Recommendation Report for Planning Permission for Works or Extension to a Dwelling

REF NO: FP/12/19/HH

LOCATION: 12 Summerley Lane
Felpham
PO22 7HP

PROPOSAL: Two storey side extension.

PROPOSED FIRST FLOOR PLAN

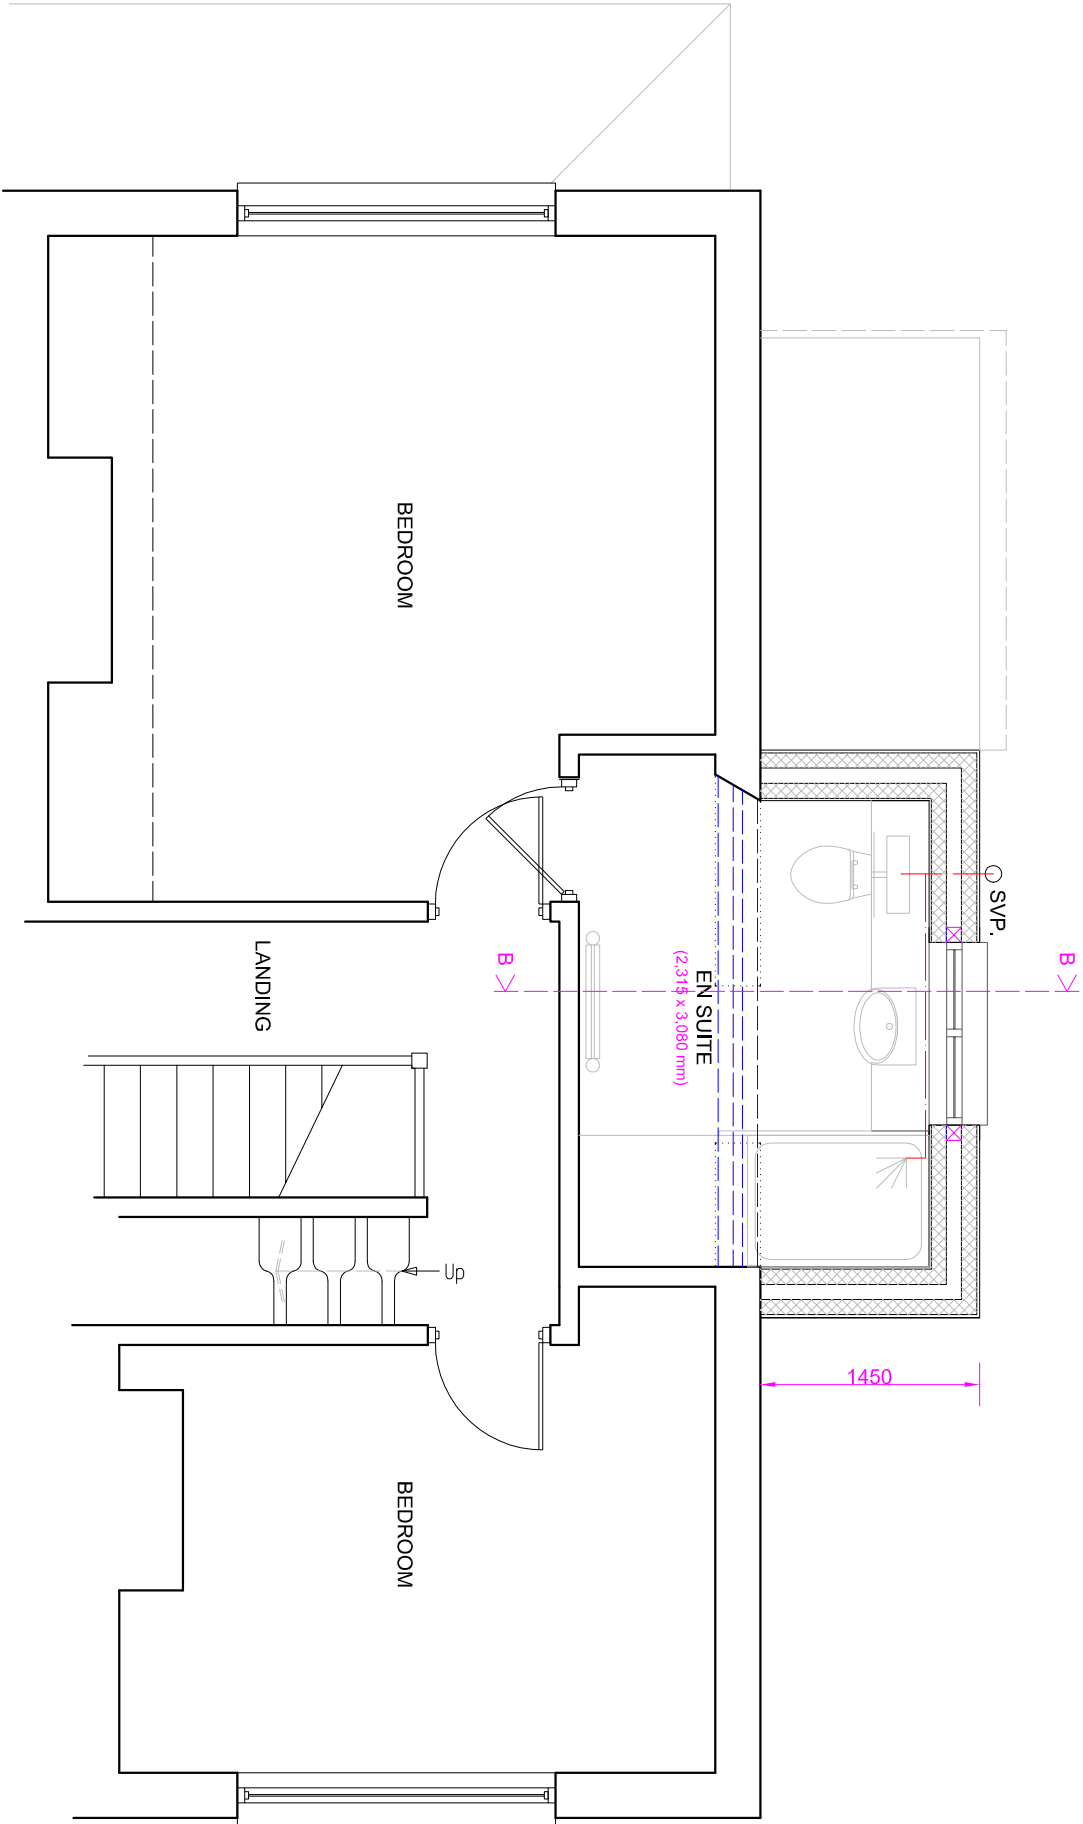
There are no first floor windows to the neighbouring property (No.14) however with 2 ground floor windows there may be some slight overshadowing as a result of the two storey addition however this is not deemed significant due to the separation distance to the boundary at 1.5m. The extension will construct a first floor window to the southern elevation however this will be obscured as shown on the plan and to ensure there is no adverse overlooking.

Reason: To comply with Section 91 of the Town and Country Planning Act 1990 (as amended).
- 2 The development hereby approved shall be carried out in accordance with the following approved plans
 - Proposed Block Plan
 - Location Plan
 - Proposed Elevations - Rev C
 - Proposed First Floor - Rev A
 - Proposed Ground Floor Rev A
 - Proposed and Existing Roof Plan
Reason: For the avoidance of doubt and in the interests of amenity and the environment in accordance with policy DDM1 of the Arun Local Plan.
- 3 The first floor window to the southern elevation of the extension shall at all times be glazed with obscured glass and only openable at a high level, at least 1.7m above finished floor level.

PROPOSED ELEVATIONS

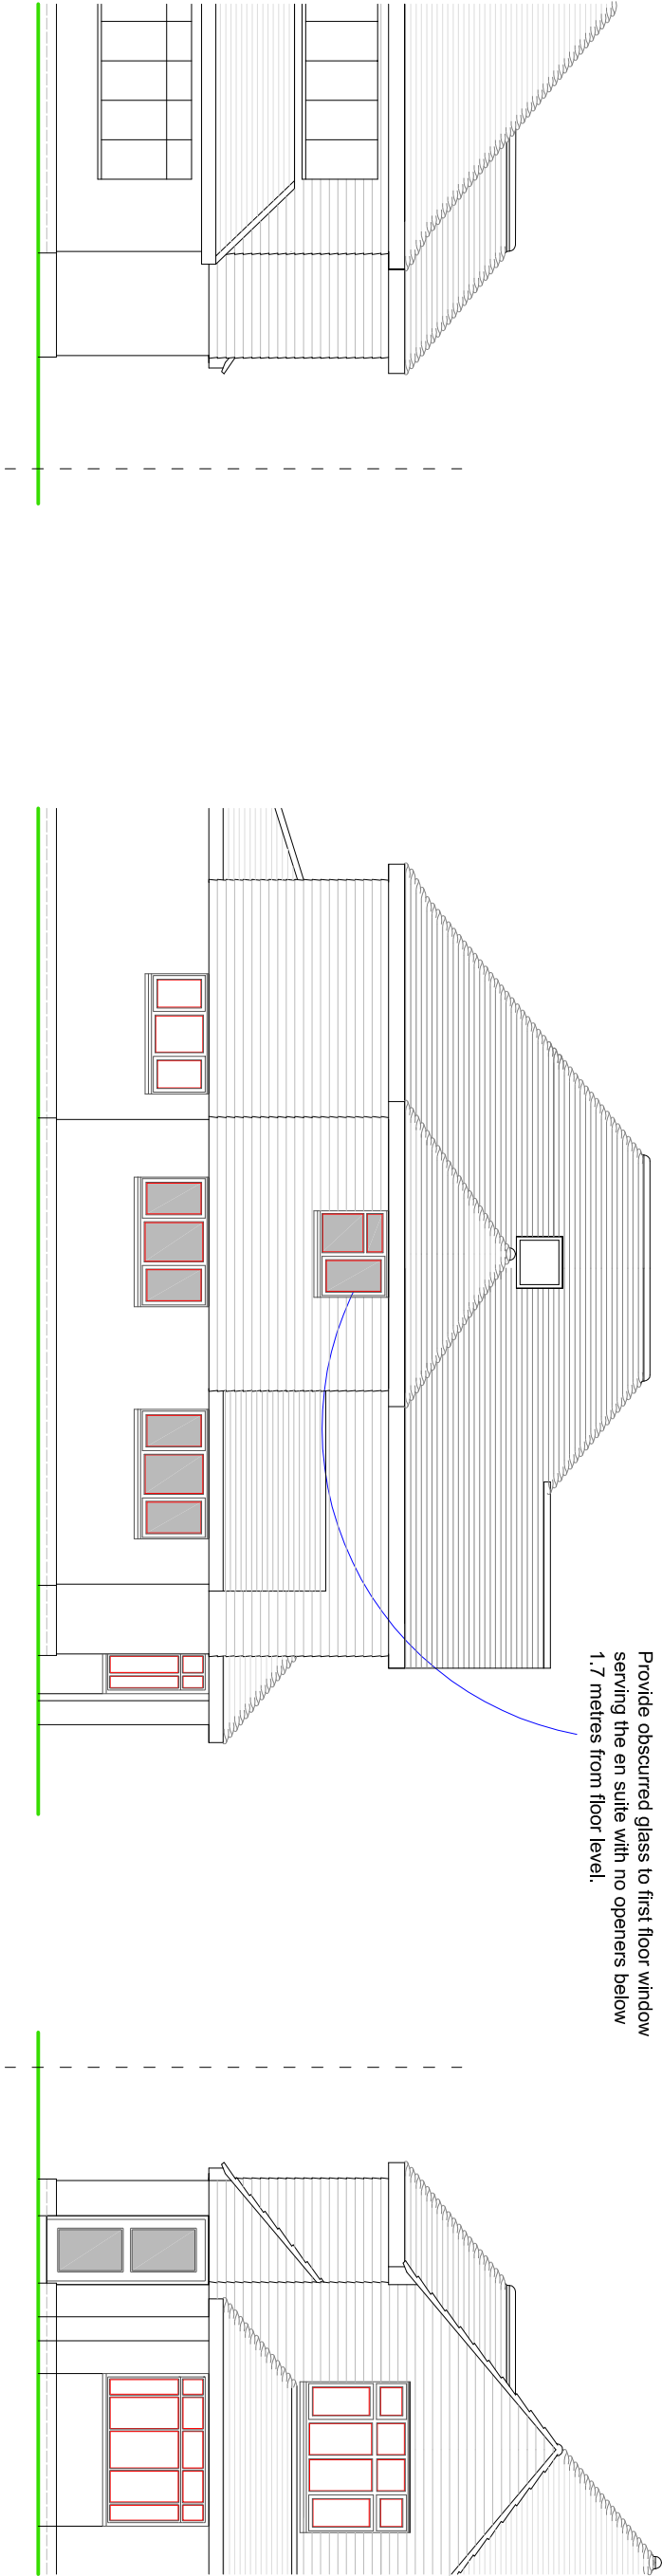
The proposal is situated to the side of the property and is therefore visible from the street scene. There is an existing porch to the southern elevation however this is to be replaced with a part single and two storey extension. The extension appears subservient to the host dwelling. It does not extend beyond the principal elevation and as a result does not appear unduly dominant retaining 10m to the front of the property.

Grey cladding is also proposed to the upper elevations of the property. The neighbouring property(No.14) has similar cladding to the side elevation and whilst there are few other examples of cladding in the area, properties are of a varied style and design and it is therefore not considered to give rise to any adverse impact and appear significantly out of character with the area.

The proposed extension will extend 1.45m in width from the south elevation. It will extend 6.5m along the side elevation with the rear 3.75m at two storey height. The extension will have a lean to roof to the front and eaves to 2.4m. This will then increase to form two storey however will sit well below that of the ridge height of the host dwelling.

Reason: To protect the amenities and privacy of the adjoining property in accordance with policies DDM1 of the Arun Local Plan.
